# A303 Sparkford to Ilchester Dualling Scheme TR010036

## 9.39 Deadline 8 Report

## Deadline 8 Report

| <b>Application Document Reference</b>         | 9.39  |

Drawing Title
OUTLINE DRAINAGE WORKS PLANS
REGULATION 5(2)(p)
SHEET 1 OF 4

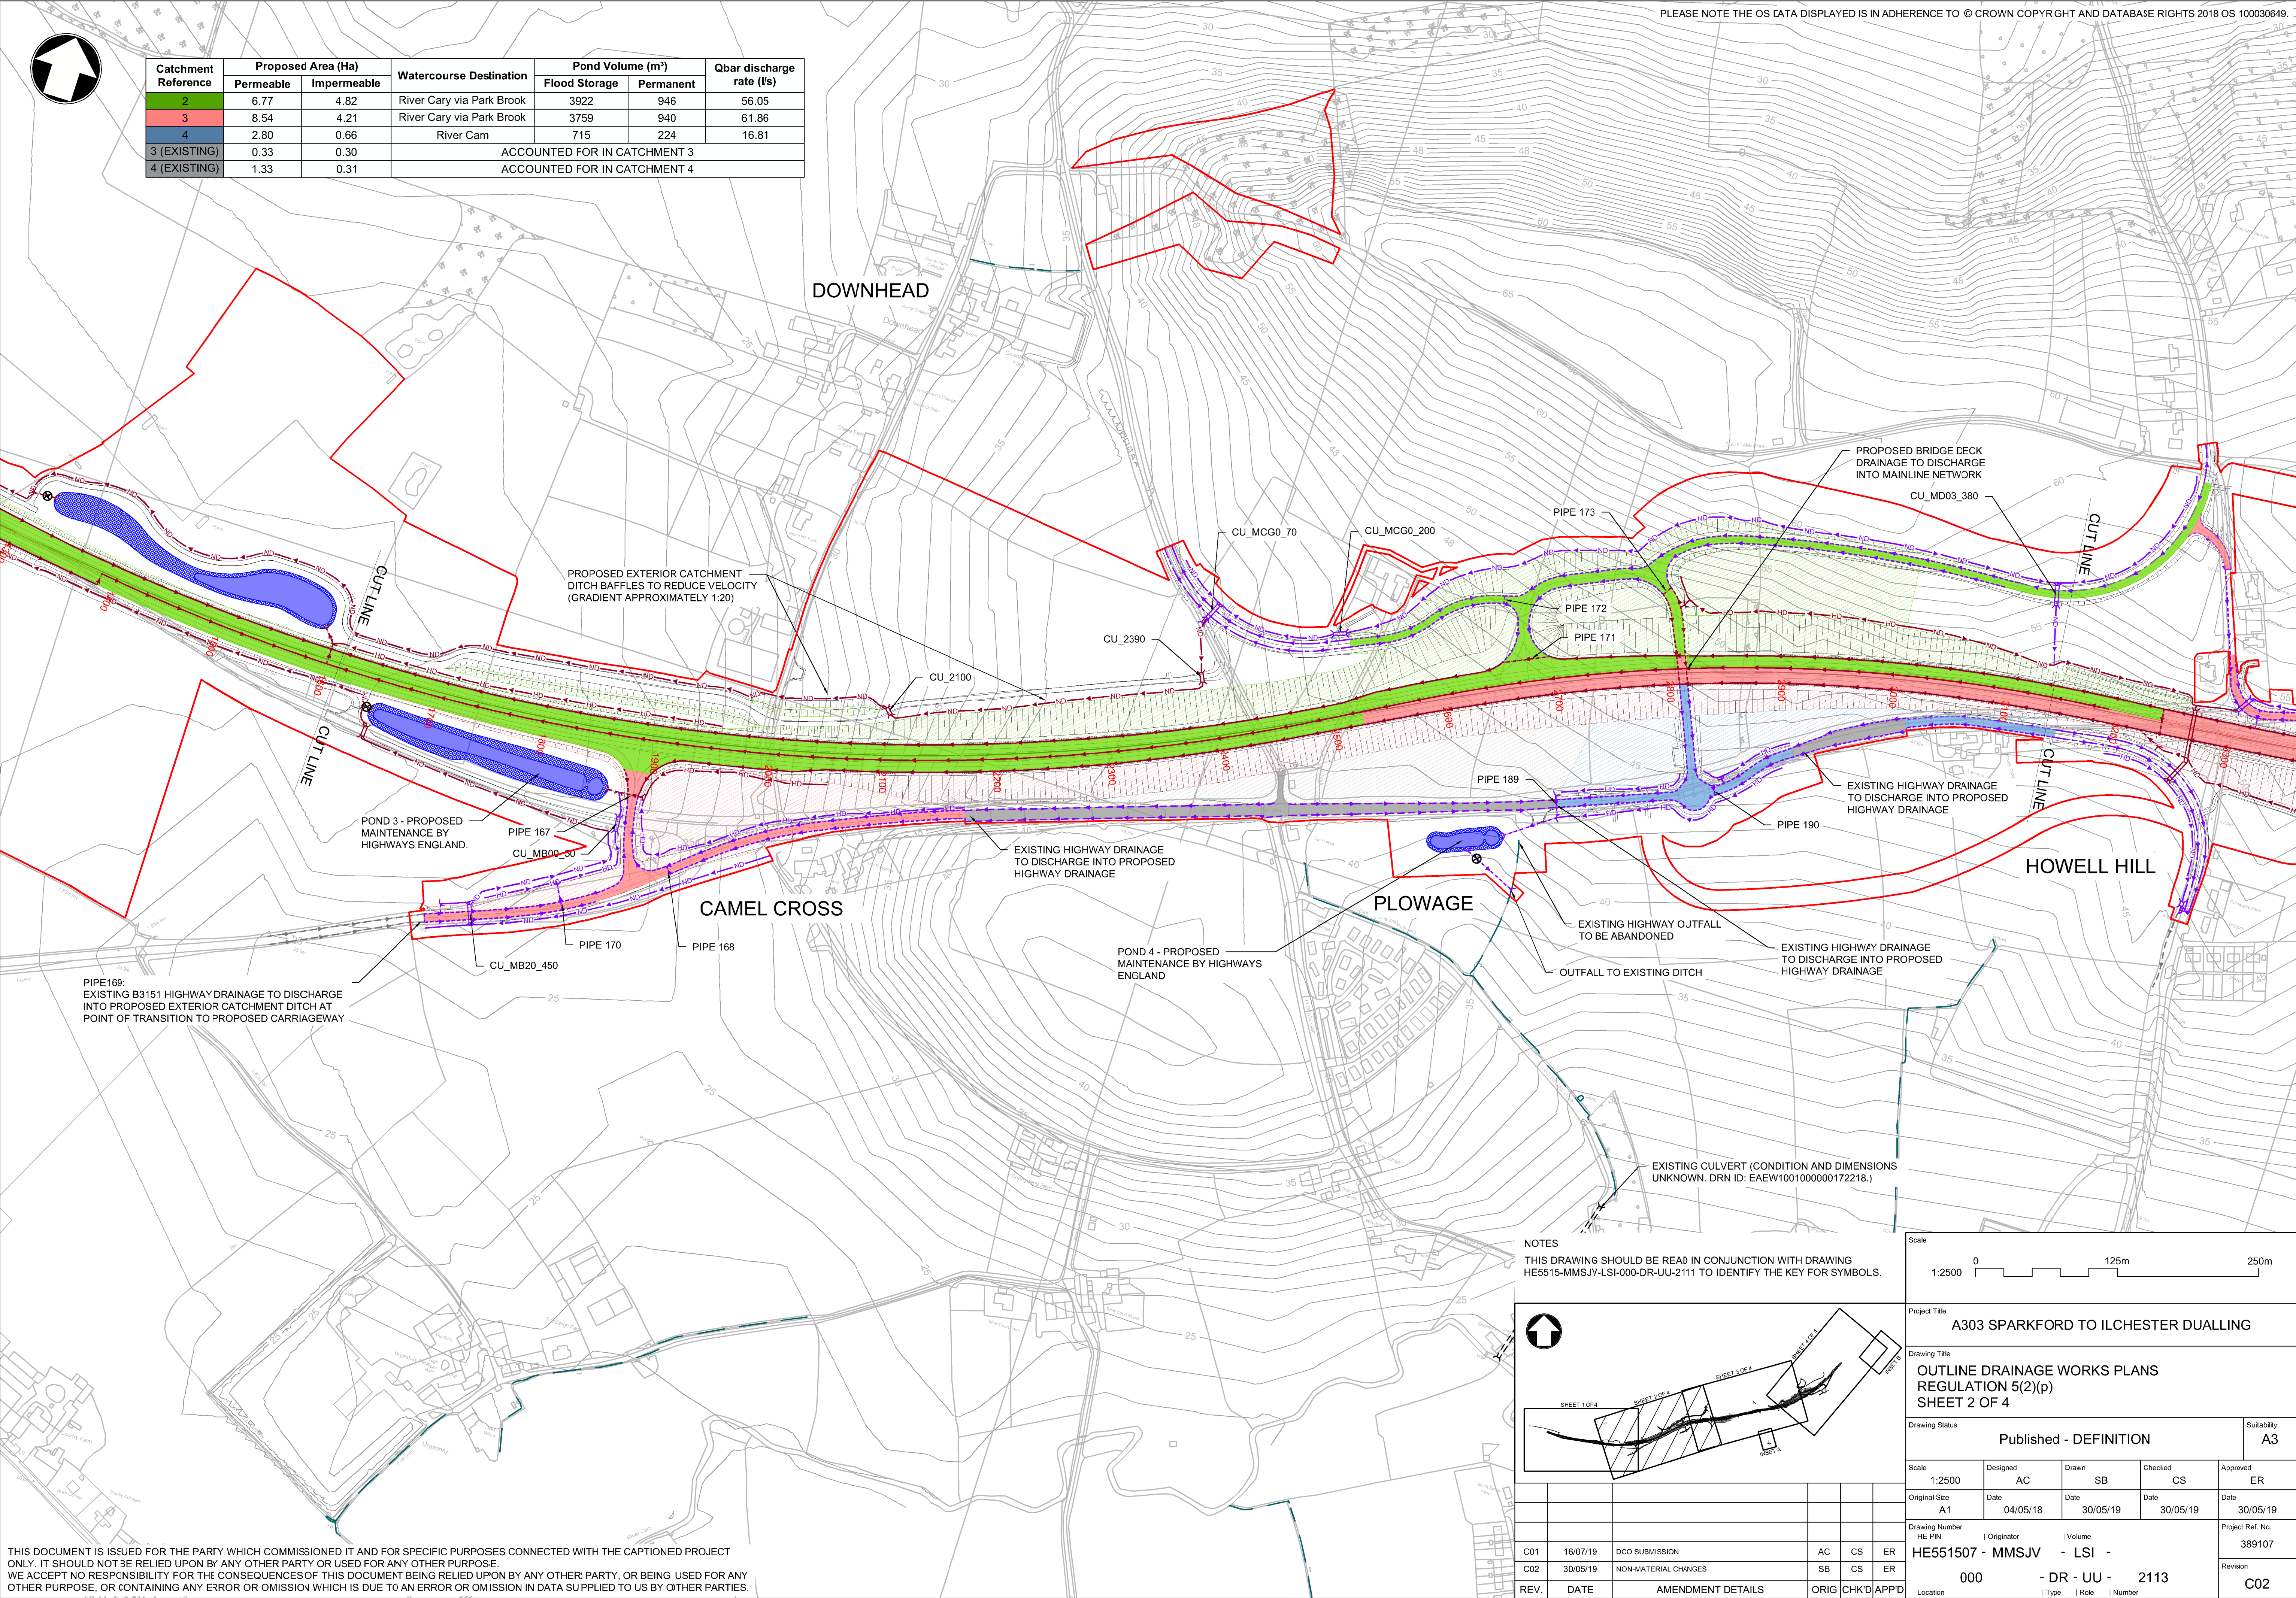
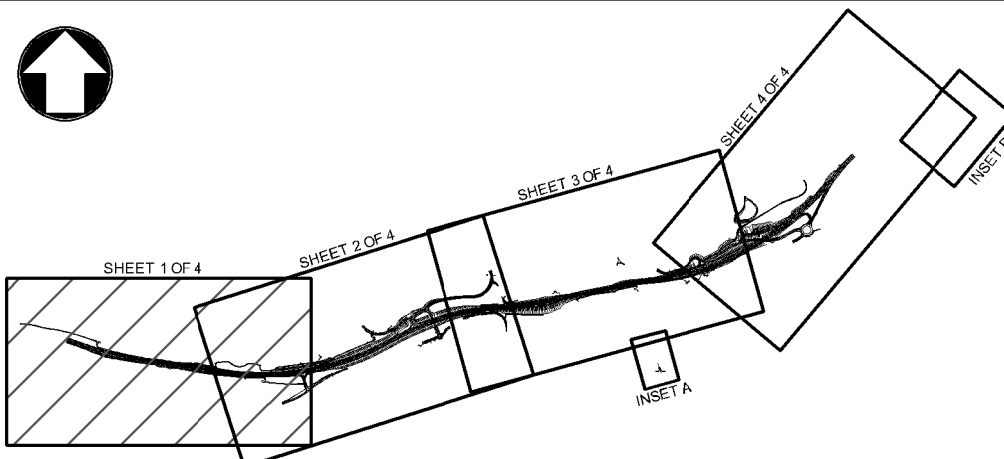
- 3.5.1 The Rule 17 letter (PD-020) requests: *In respect of Bund 7 could the Applicant please explain why the drainage arrangement could not be redesigned so that the two culverts are moved to the east, thus allowing Bund 7 to be extended eastward, or why the proposed culverts could not be extended in length to allow an extension of Bund 7 overhead, or why an attenuation pond could not be included on the southside of the main carriageway to avoid the need for the culverts to the north. If an extension of Bund 7 is not technically feasible, could the Applicant set out what alternative screening measures it has considered and why the environmental barrier (albeit a wooden fence) has been chosen.*

- 3.5.2 As stated in the Applicant's non-material change request cover letter (REP6-014), the Applicant investigated the possibility of extending Bund 7 to the east in order to avoid the need for the timber fence alongside the proposed dual carriageway in the south eastern corner of the park. However, this was not possible as it would have compromised proposed drainage outfalls from the carriageway for the reasons outlined in the following paragraph.

- 3.5.3 It is good design practice to consider the impacts of scenarios where the design limitations of drainage systems are exceeded (that is, during periods of exceptionally high rainfall). At this location, the A303 carriageway is generally impounded along its northern perimeter by proposed bunds and the existing cutting to the east of Bund 7. Under normal rainfall conditions the carriageway

drainage systems will operate as designed. However during exceptionally high rainfall these systems will become overwhelmed and, whilst it is not necessary to accommodate high flows within the designed drainage systems, it is important to consider where this 'exceedance runoff' would flow so that its impact is minimised. It is good practice to ensure that exceedance flows do not impact the operation of critical infrastructure such as transport links. The gap between Bund 7 and the adjacent cutting provides a route for any exceedance flows to leave the carriageway whereas if Bund 7 was to be extended further east this would not be possible, and the A303 might become flooded.

- 3.5.4 As such, instead of extending Bund 7, it is proposed to provide additional localised screening planting at this location to soften the appearance of the fence.
- 3.5.5 The wooden fence environmental barrier was chosen as this will provide visual screening from visual receptors within the Registered Park and Garden during Year 1, whilst the proposed planting establishes. By Year 15, it is anticipated that the proposed planting will then provide additional screening. As part of the Applicant's non-material change request and in order to soften the views of the wooden barrier, in line with South Somerset District Council's concerns, additional localized screening planting at this location has now been proposed, as shown on the latest version of the environmental masterplan (REP7-030).
